Application Ref:	3/2026/0137			 Ribble Valley Borough Council www.ribblevalley.gov.uk				
Date Inspected:	28/10/25	Site Notice:	1/5/26					
Officer:	BT							
DELEGATED ITEM FILE REPORT:					APPROVAL

Development Description:	Proposed single storey extension to side.
Site Address/Location:	Wiswell Eaves Barn, Pendleton Road, Wiswell, BB7 9BZ.

A3.3B

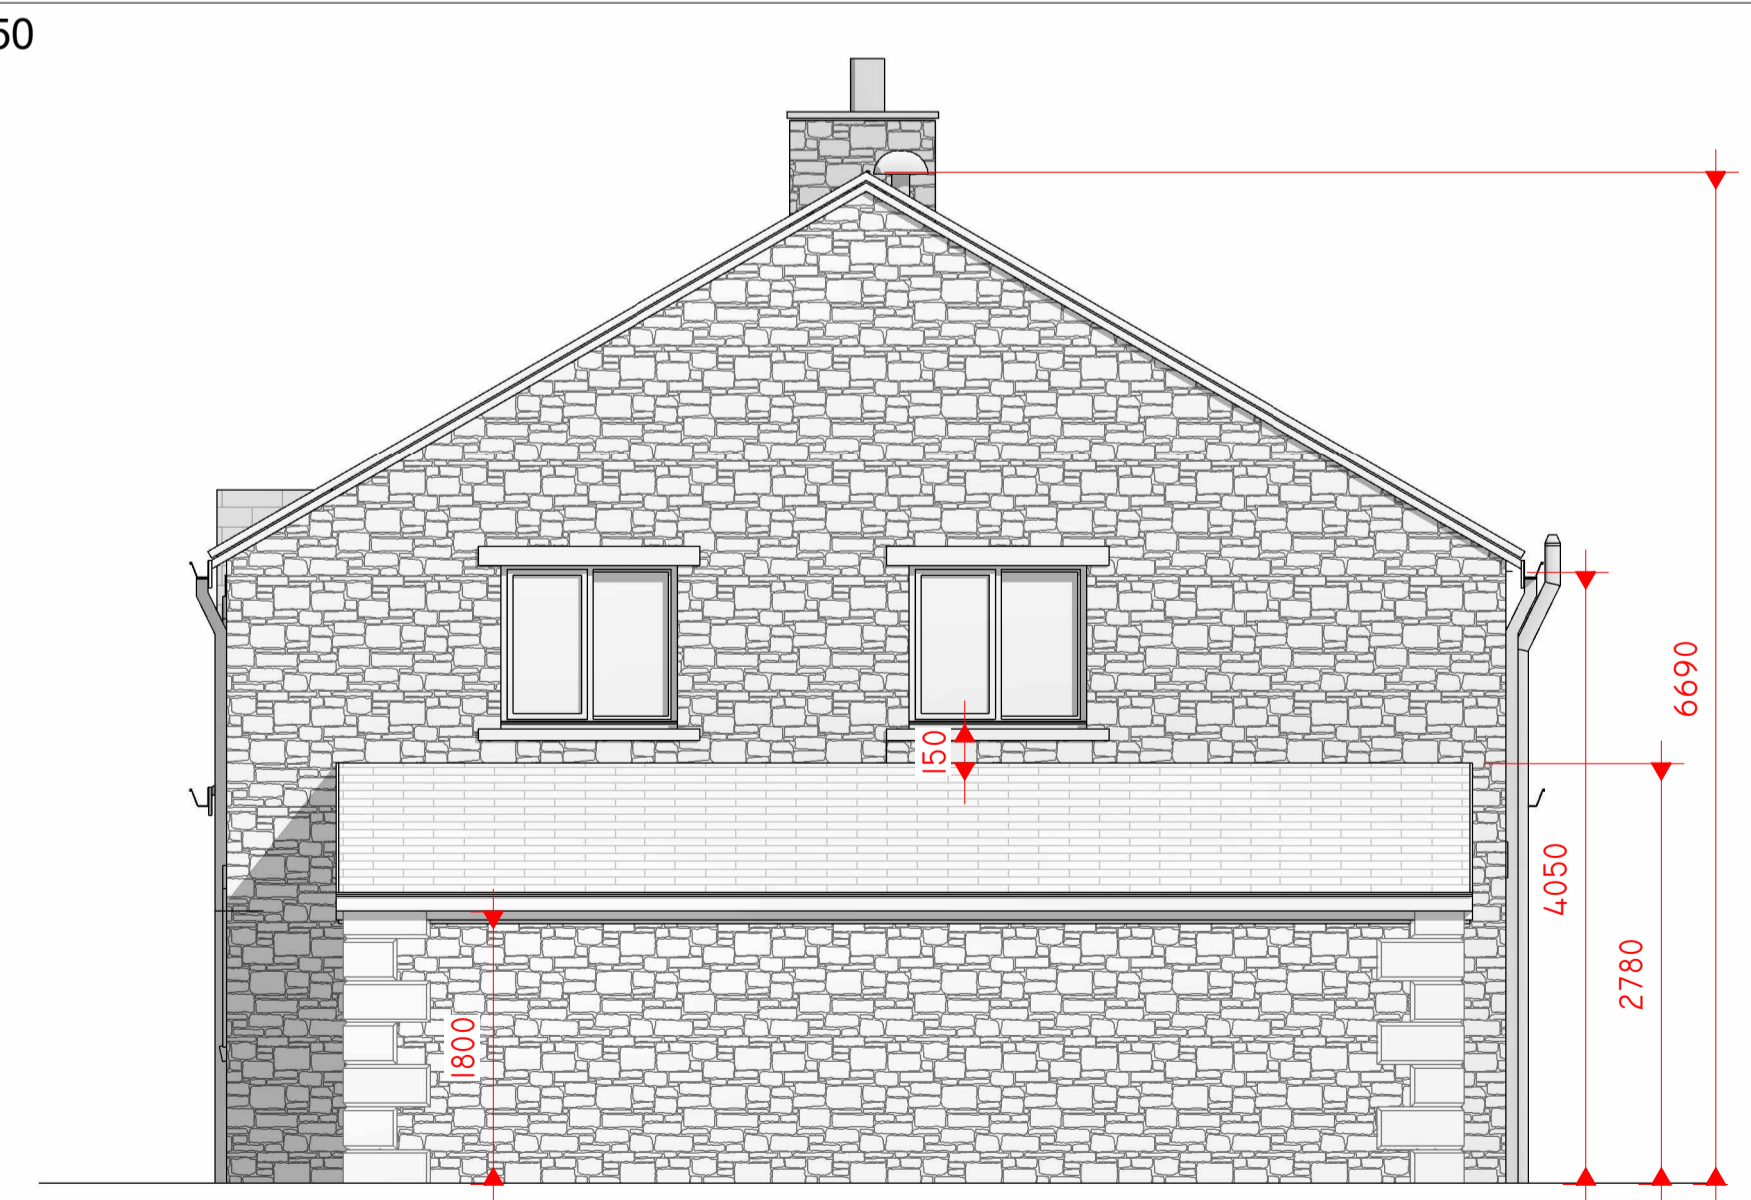
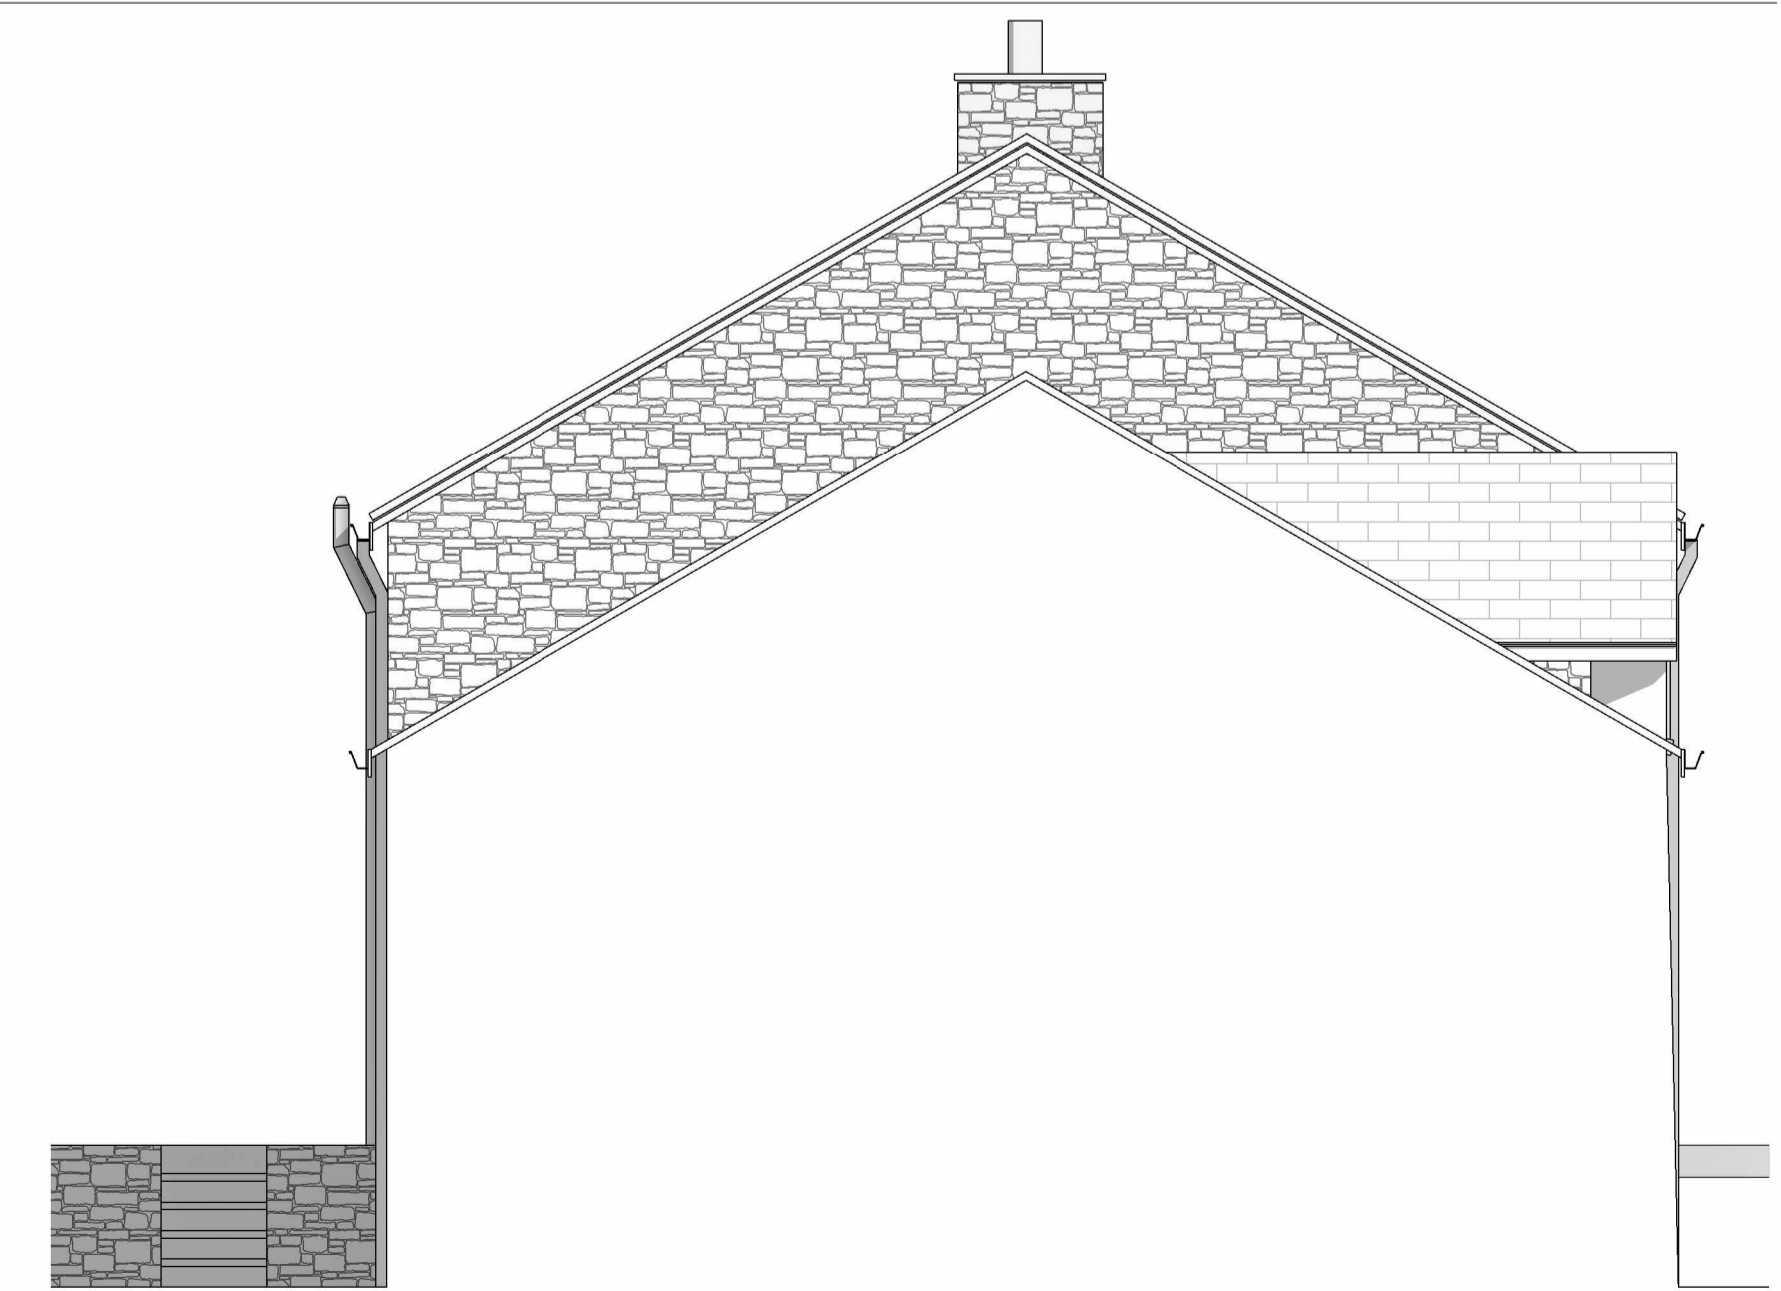
In this instance, the original side extension proposed for the property comprised its front and rear elevations aligned flush with the front and rear elevations of the host property and as such read as an over dominant and unsympathetic addition to the parent dwelling by virtue of its bulk and massing. Three rooflight features were also originally proposed for the extension which were considered to exacerbate the visual impact of the proposal, with none of the proposed rooflights serving a habitable space. As such, the development as originally submitted was not considered to be a sympathetic form of development and the applicant was therefore asked to give consideration to an extension of reduced proportions along with the omission of the proposed rooflight features.

An amended proposal has since been submitted with the depth of the extension reduced by virtue of stepped in front and rear profiles. In addition, the originally proposed rooflight features have been omitted from the proposal. Furthermore, the proposed extension would consist of stone elevations, timber windows and slate roof tiles, all of which would be in keeping with the materiality of the host property and rural vernacular of dwellings in the locality. As such, the proposed extension would read as a subservient and congruent addition to the host property and for this reason it is not considered that the proposed development would detract from the character and appearance of the adjacent Grade II Listed Building Wiswell Eaves House.
